Re: Status of Improvement Permit Application #06-5-14869 - Lot 127 Woodshire

On June 1, 2006, an Environmental Health Specialist from the Harnett County Health Department attempted to evaluate your property for the purpose of issuing an Improvement Permit. This individual was unable to evaluate your property for one or more of the following reasons.

SURVEY FOR: PROPOSED PLOT PLAN - LOT - 127 WOODSHIRE S/D, PHASE FOUR		BENNETT SURVEYS, INC. 1662 CLARK RD., LILLINGTON, N.C. 27546 (910) 893-5252	
TOWNSHIP ANDERSON CREEK	COUNTY HARNETT	20 0 40	SURVEYED BY: FIELD BOOK
STATE: NORTH CAROLINA

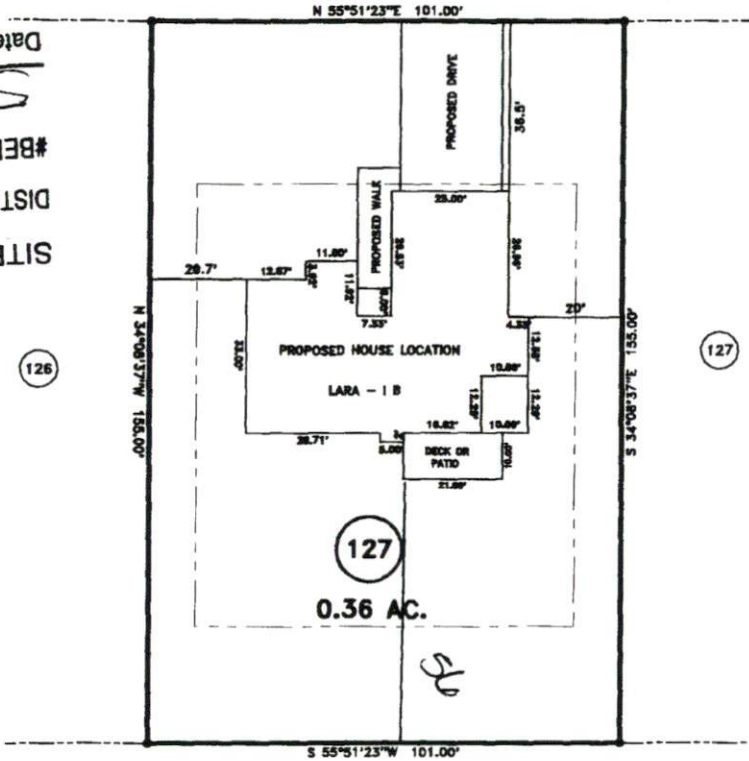
- 1. Property lines/corners not marked or labeled
- 2. House corners not marked or labeled
- 3. Directions not clear to property
- 4. Property needs brush or vegetation removed
- 5. Backhoe pits required
- 6. Other – **Please reduce number of bedrooms to 3.**
